DEVELOPMENT APPLICATION T6-13-248
LOT 2 SEC 20A DP759080, 119 RIVER STREET WEST KEMPSEY
KEMPSEY HOSPITAL REDEVELOPMENT STAGE 1

Thank you for the opportunity to comment of the redevelopment of the Kempsey Hospital.
Please find below Council's comments on the EIS:

FOR TENDER

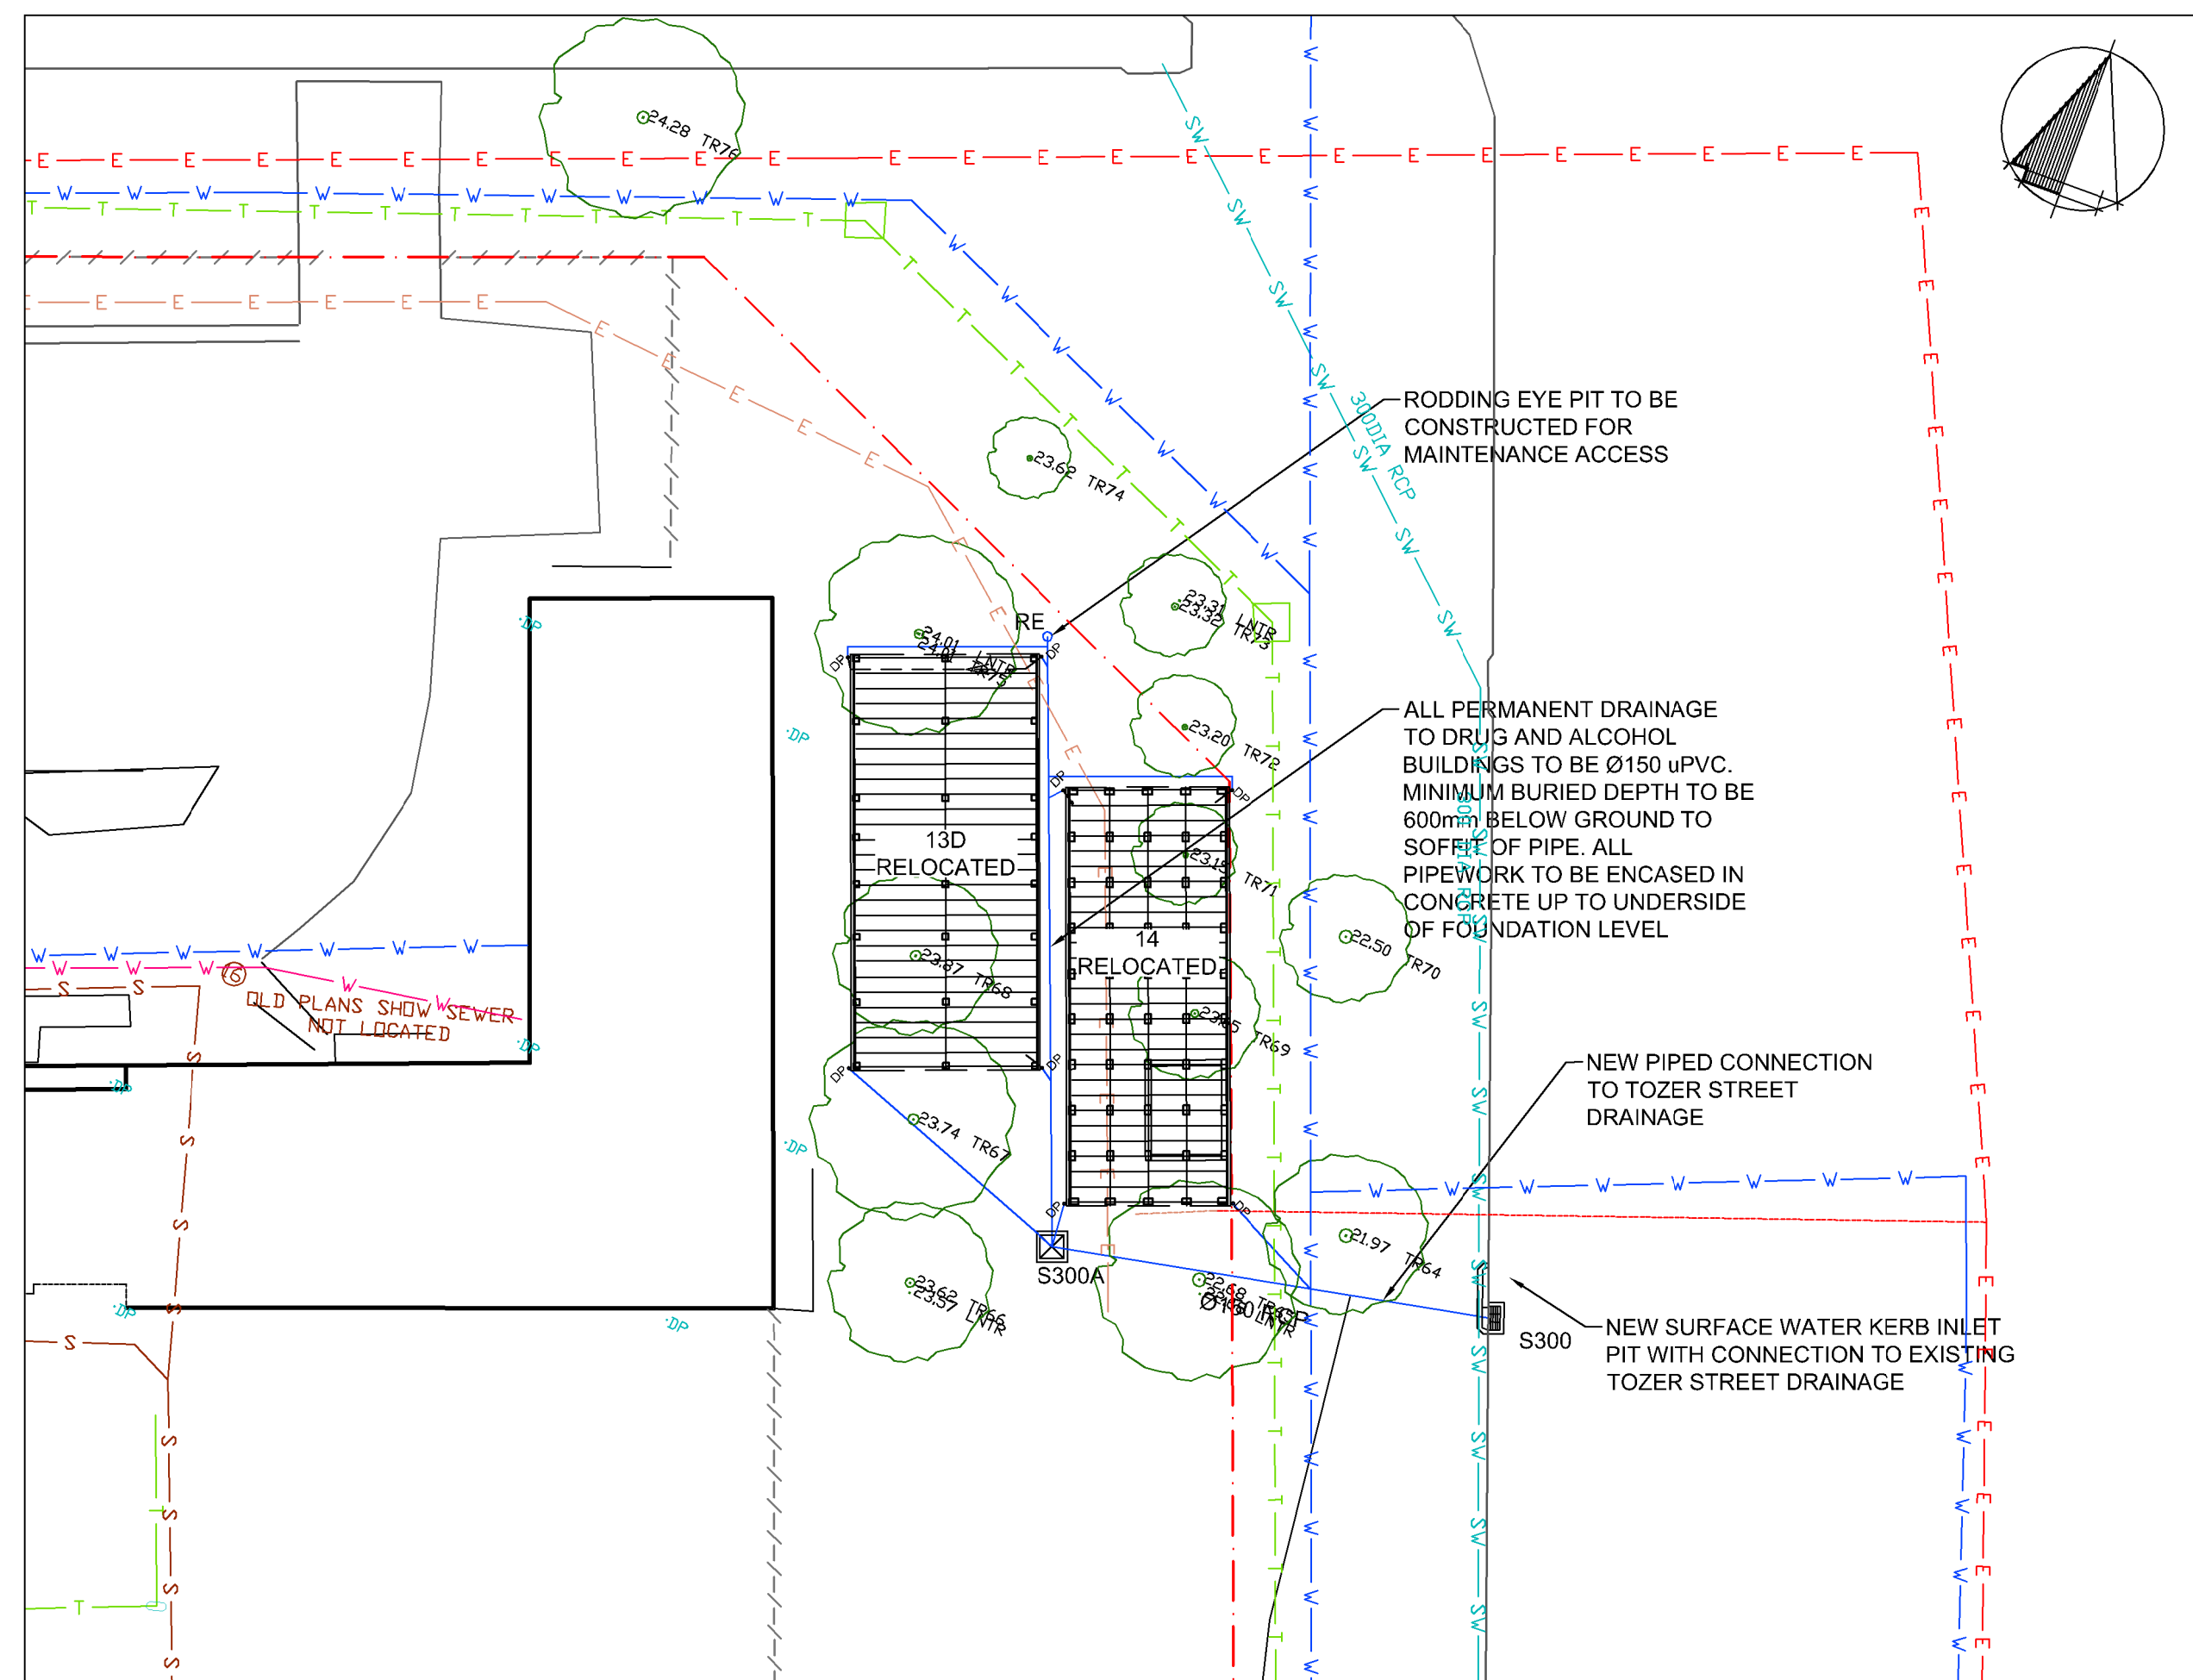
4.15.2 Stormwater Management Strategy	<ul style="list-style-type: none">There is no reference to the Enstruct's <i>Stormwater Management Plan</i> (SMP) at appendix K2;There is no mention in either the SMP or the EIS on water quality targets and means of achieving them, only that a gross pollutant capture system will be installed prior to discharge to the Macleay River which does not address water quality discharge from the site as a whole;There is no discussion anywhere in the EIS

SUBJECT	COMMENTS
	<p>or supporting documentation on the location of the proposed new piped stormwater drain outlet at the Macleay River and the method to be deployed to reduce the outlet velocity in the pipe to prevent scour at the river bank;</p> <ul style="list-style-type: none">• There are no details on the effect on the existing environment (flora and fauna habitat) at the proposed pipe discharge point at the Macleay River;
